RE: Congress Apartments
Grading and Drainage Plans
Engineer's Stamp Date: 08/5/22
Hydrology File: C13D033

Based upon the information provided in your submittal received 8/5/2022, the Grading & Drainage Plan is not approved for Building Permit until the following comments are addressed:

NOTE:
THIS PLAN PROVIDES THE LOCATION AND ELEVATIONS OF ALL PROPOSED RETAINING WALLS. THE STRUCTURAL DESIGN OF ALL RETAINING WALLS ARE PROVIDED BY OTHERS.

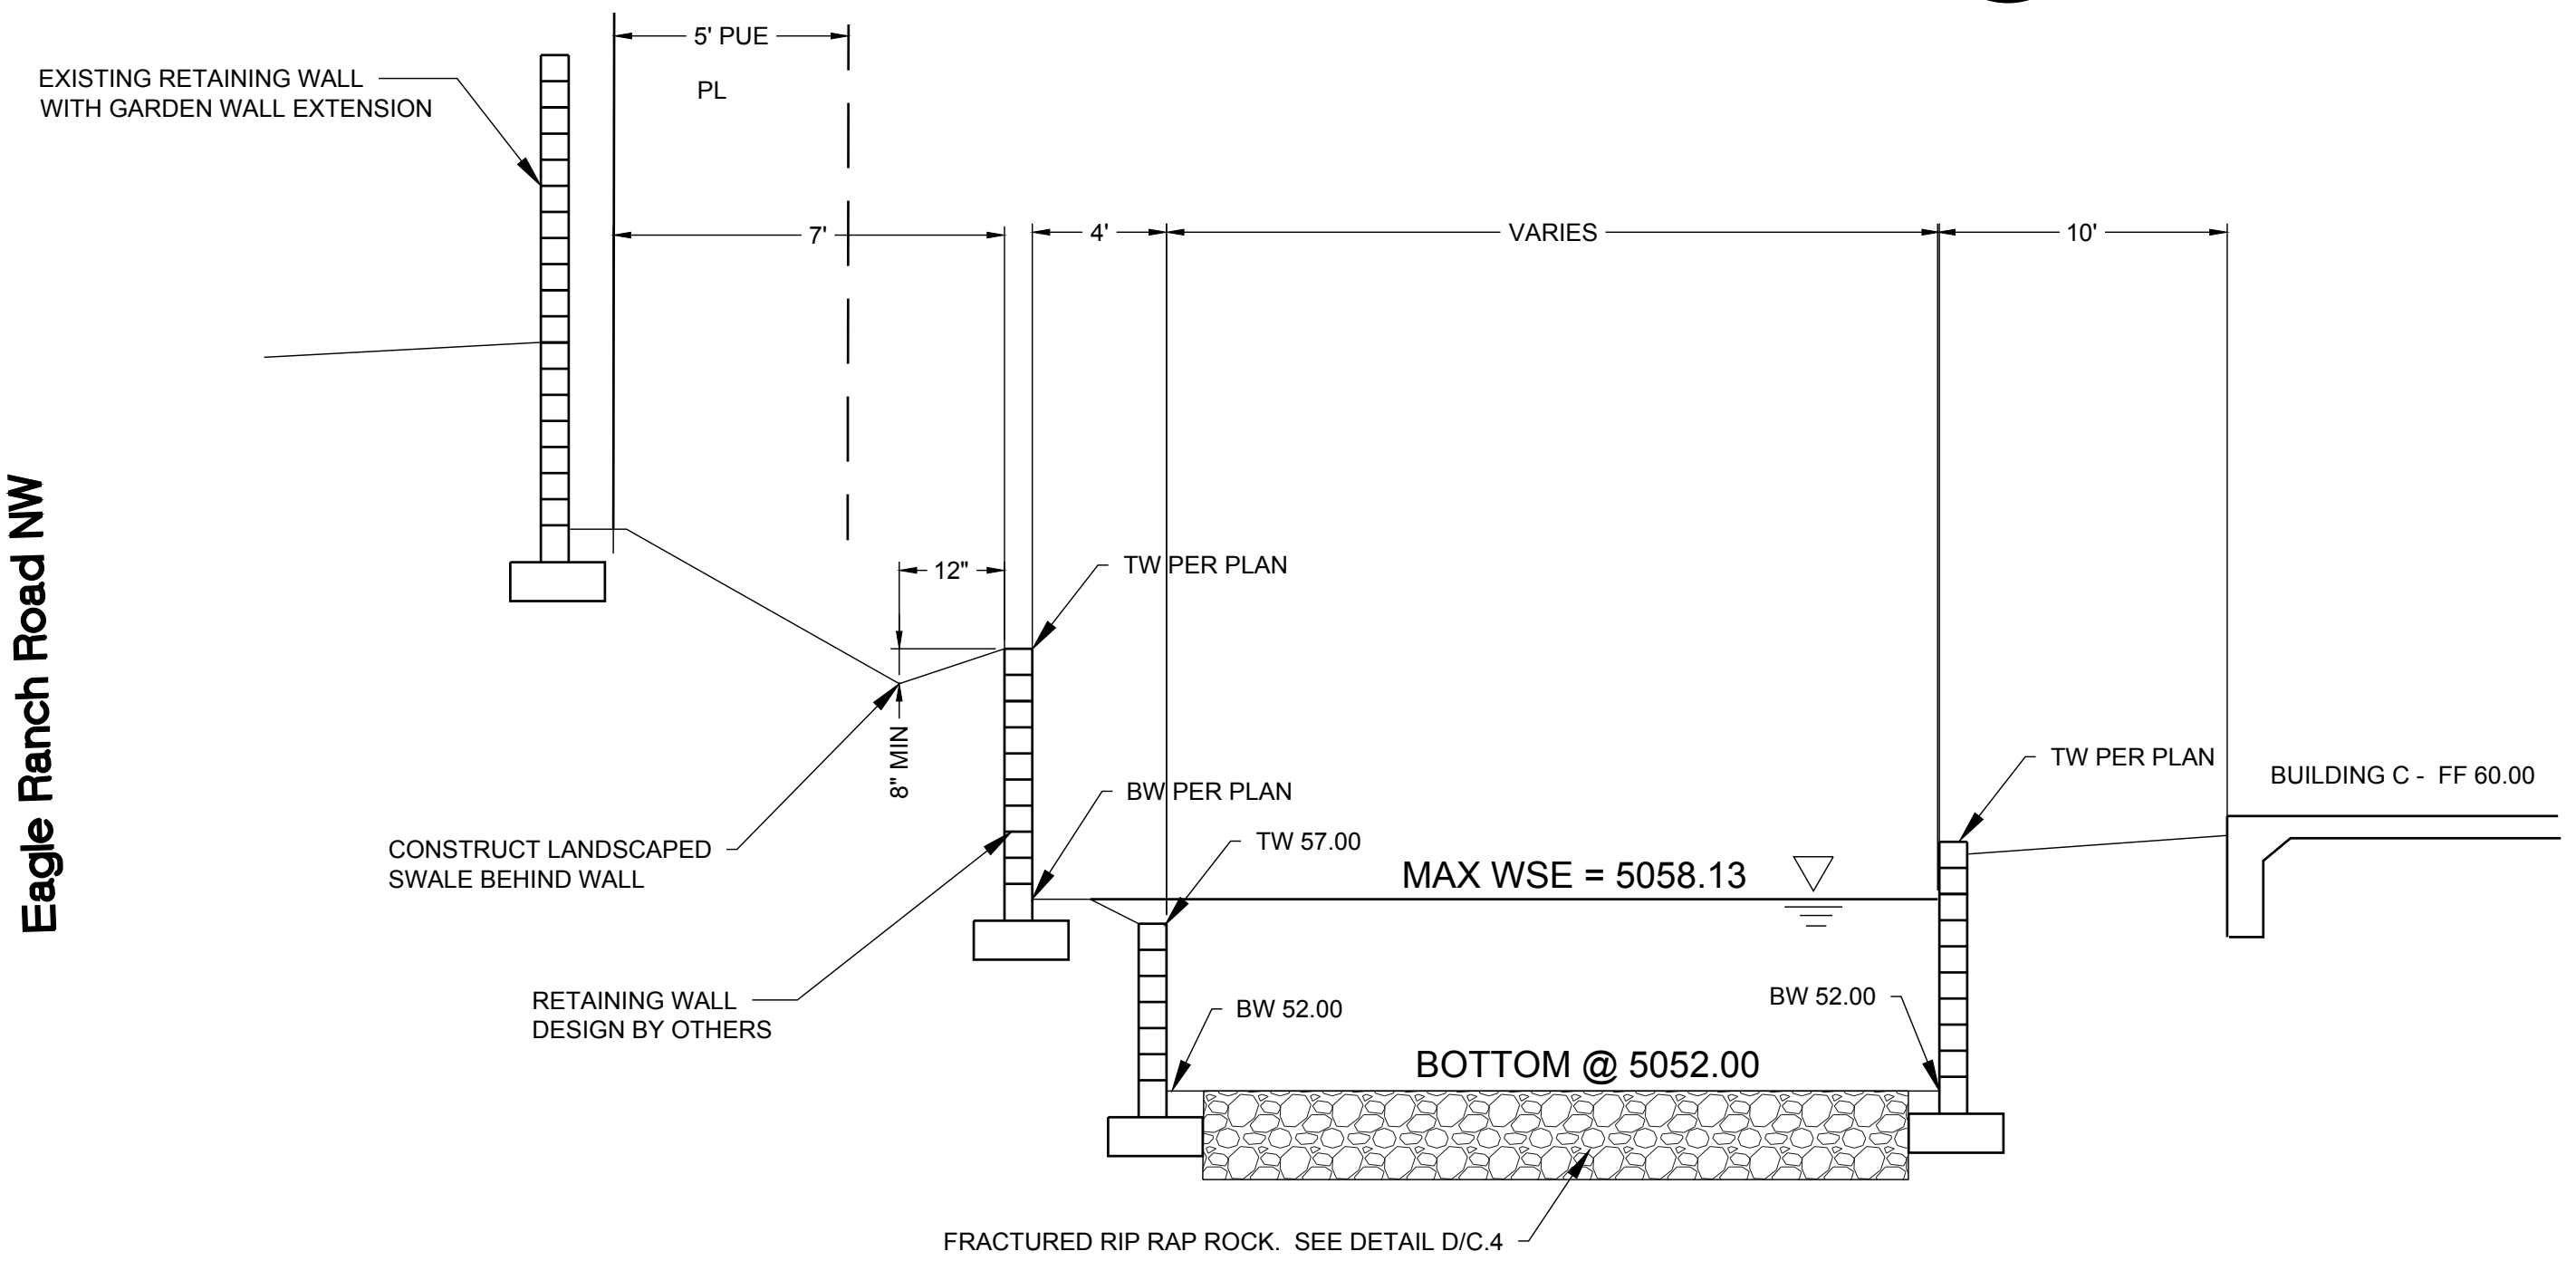
6. On the retaining wall plan , provide TW/BW rather than TW/FG as sometimes FG grade is higher and lower than the TW grade.
7. What is the significance of the linework that juts into the drive north of the parking area between buildings B and C?
8. For Sections B, C, D and E on Sht C.4 provide the depth of the invert in the landscape area.
9. Pond slopes are to have aggregate. This comment may be moot per comment 2.a.
10. From reviewing contours in our GIS, it appears that north-bound Eagle Ranch Rd is lower than south-bound Eagle Ranch Rd. Please confirm with spot elevations at the northbound flowline to justify not providing the standard water block of 0.87 inches at the property line.
11. Please increase the font size for the First Flush Criteria.
